From: Richard Castro-Parker
Sent: 10 July 2019 11:49
To: Planning.Responses
Subject: FW: Windroos, Littlehampton
Attachments: Calculations.zip; DRAWINGS.zip

1. There are inconsistencies between the modelled depths and depths shown on plan of soakaways. Furthermore, some of the soakaways have depths greater than the difference between the cover (nearby levels, levels not given at soakaway) and invert levels specified. Please ensure that minimum cover requirements are met and that details are consistent. Cover levels have been added to soakaway structures and minimum cover levels have been ensured.

There are still some issues with the details:

Title		Concrete Ring Soakaway		
Scale	1:20	At original	A4	© Robert Clark Associates Ltd
Drawing Number	1767/D5.2			Revision
				-

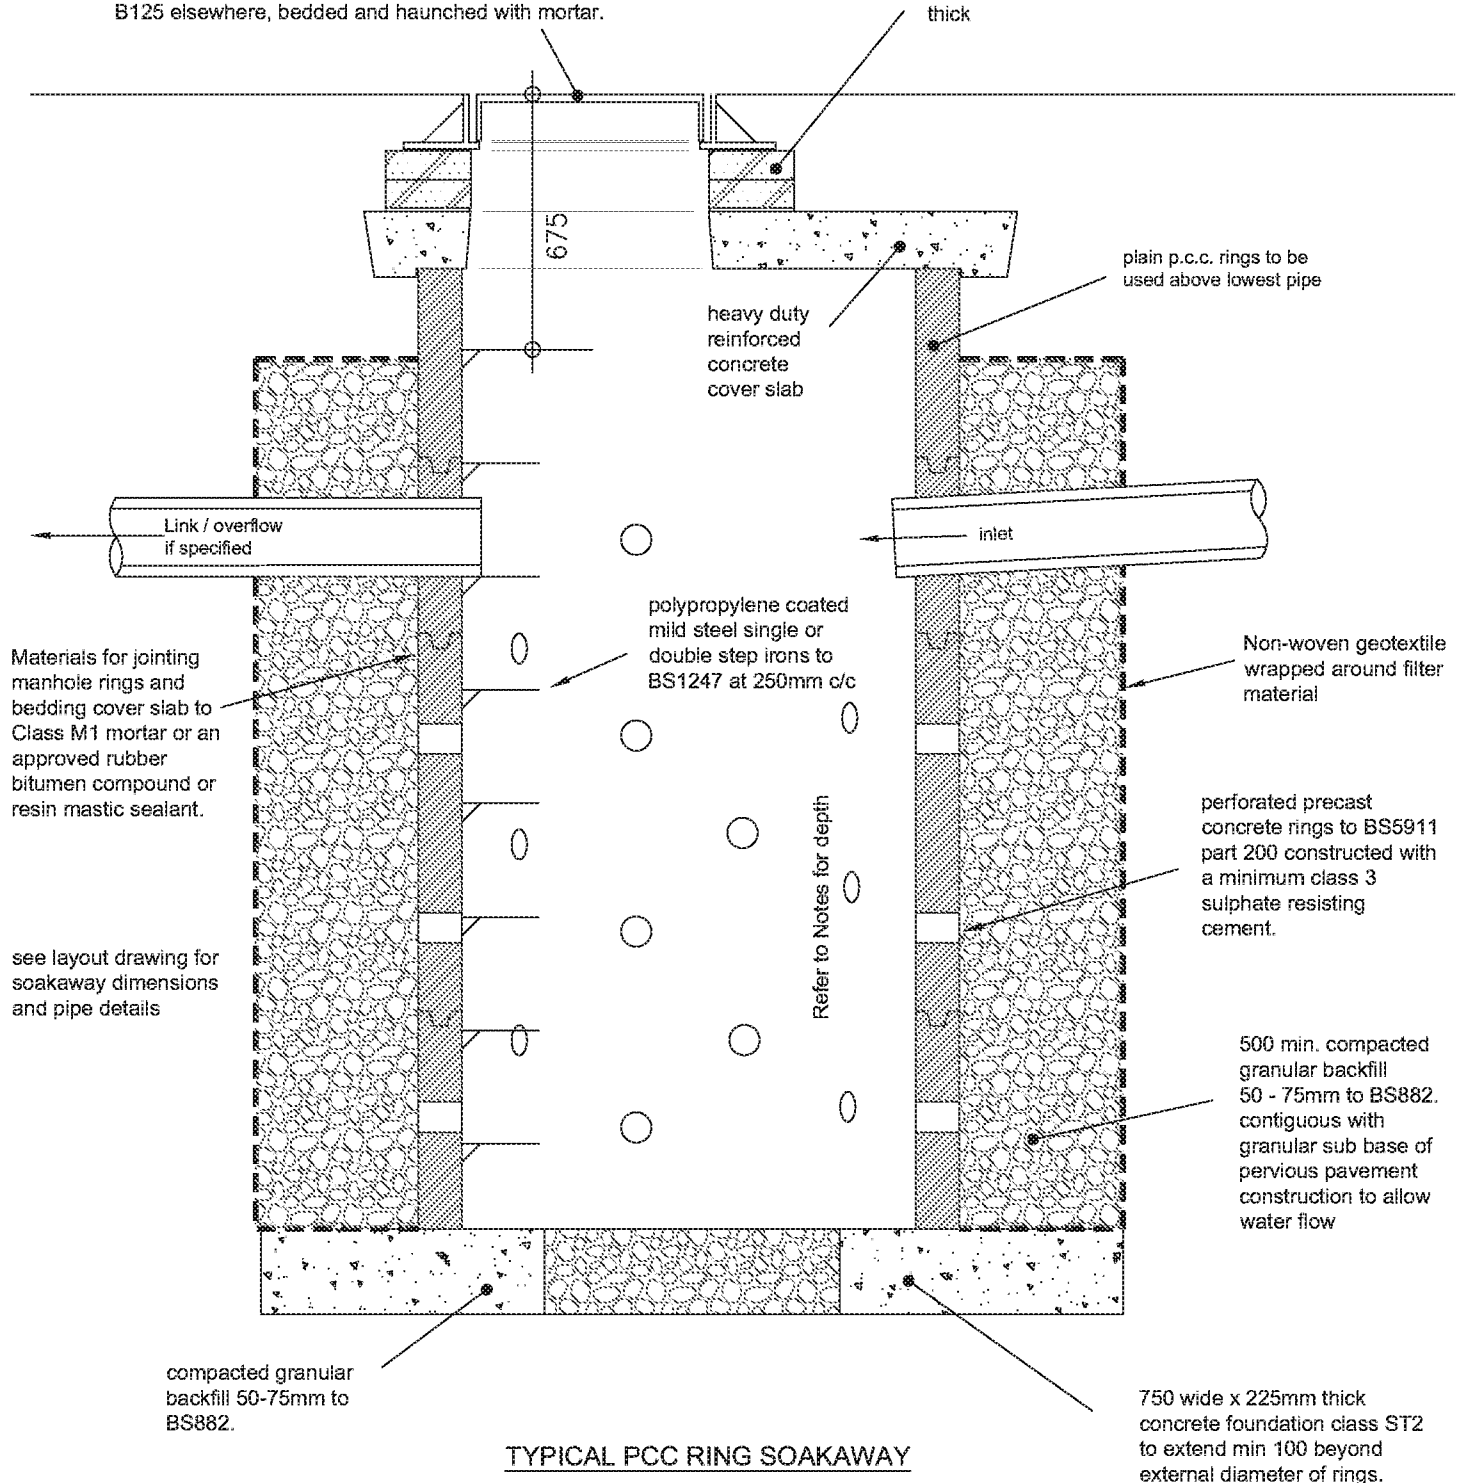
6. Cover levels at soakaways are not provided. These must be detailed.
7. Catchpits need to be labelled with sump depths.
8. Ring soakaway drawings need updating to show step irons, clean granular surround, geotextile, hole in base, etc. Please see attached document for an example.
9. Construction detail drawings need to be provided of pipe bed and surround, manholes and catchpits.

8. Ring soakaway drawings need updating to show step irons, clean granular surround, geotextile, hole in base, etc. Please see attached document for an example.
A construction detail has been provided for the ring soakaways.
9. Construction detail drawings need to be provided of pipe bed and surround, manholes and catchpits.
Construction details for these items have been provided as attached.

Checked By	Checked Date	Drawn By	Drawn Date
RW	27.03.19	AS	26.03.19
Client Drawing No.		Scale	
		1:250	(AT A1 SIZE)
PBA Drawing No.		Revision	
147.5001.400		B

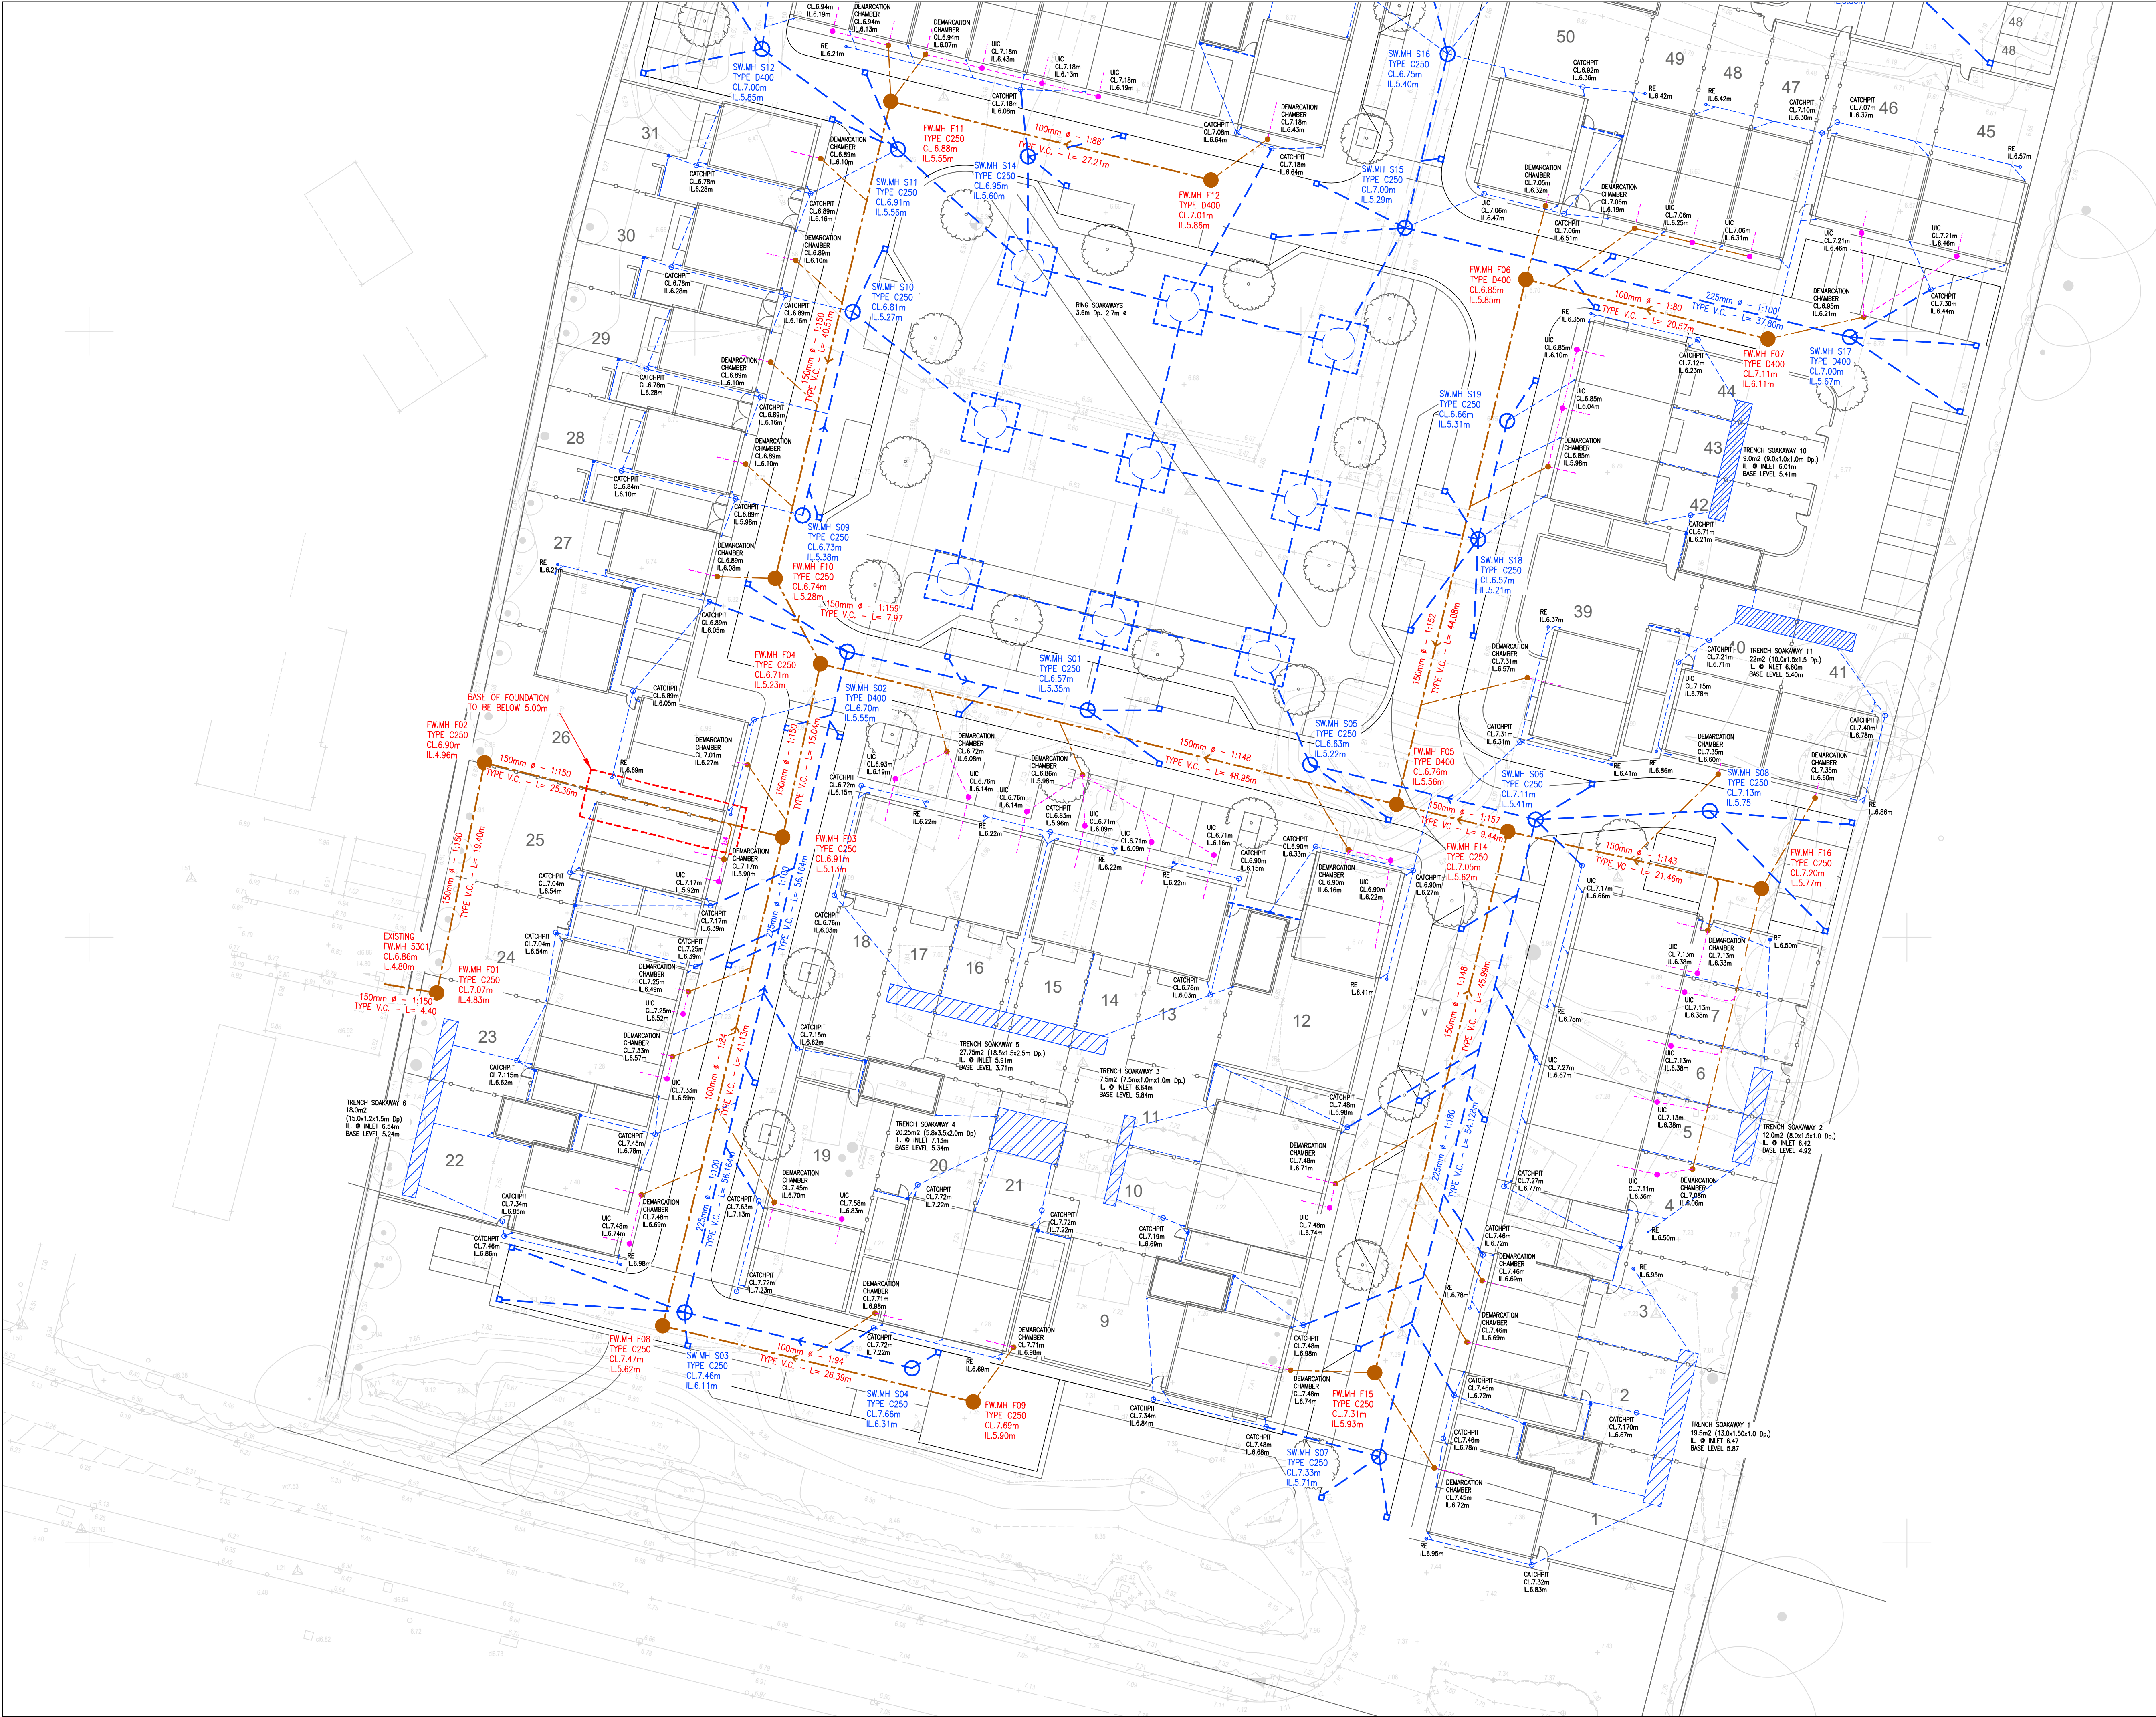
1. There are inconsistencies between the modelled depths and depths shown on plan of soakaways. Furthermore, some of the soakaways have depths greater than the difference between the cover (nearby levels, levels not given at soakaway) and invert levels specified. Please ensure that minimum cover requirements are met and that details are consistent.

3. The calculation for 5 ring soakaways use a diameter of 3m. Yet 2.7m diameter is specified on plan. Again calculations and details need to be consistent.

4. Updated calculations for the 9 ring soakaways have not been provided and need to be.
5. Catchpits are not shown upstream of all connections into soakaways. These must be provided.

3. The calculation for 5 ring soakaways use a diameter of 3m. Yet 2.7m diameter is specified on plan. Again calculations and details need to be consistent. The 5 no. ring soakaways have a diameter of 3.0m which is now reflected in both the plans and on the calculations.

4. Updated calculations for the 9 ring soakaways have not been provided and need to be. These are provided as attached.
5. Catchpits are not shown upstream of all connections into soakaways. These must be provided. Catchpits have been included upstream of all soakaways.

6. Cover levels at soakaways are not provided. These must be detailed. These are now included in the plans.
7. Catchpits need to be labelled with sump depths. Sump depths included in the plans.
